WEST SUSSEX COUNTY COUNCIL CONSULTATION

TO:	Arun District Council FAO: Jessica Riches
FROM:	Stephen Gee WSCC – Highways Authority
DATE:	10 September 2025
LOCATION:	Land at Ford Airfield Ford
SUBJECT:	F/15/24/RES Approval of reserved matters (layout, scale, appearance and landscaping) following outline permission F/4/20/OUT for phase reserved matters1 (North), for the erection of 340 No. residential dwellings plus associated roads, infrastructure, parking, landscaping, open space & play areas and associated works. This application affects a Public Right of Way, may affect the setting of a Listed Building and falls within CIL Zone 1 (Ford strategic site - zero rated).
DATE OF SITE VISIT:	n/a
RECOMMENDATION:	Advice

**Project Title:** RM1 - VEHICLE TRACKING AND VISIBILITY PLAN (SHEET 1 OF 2)

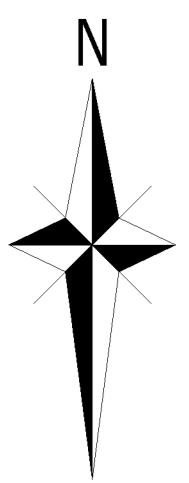
It is noted that on some side roads the visibility splays appear to cross the front gardens of the properties e.g 27, 41, 335, 281. The applicant acknowledges this and restrictive covenants are suggested as a way of keeping the splays clear.

Trees that were previously within visibility splays have either been removed or moved out of the splays.
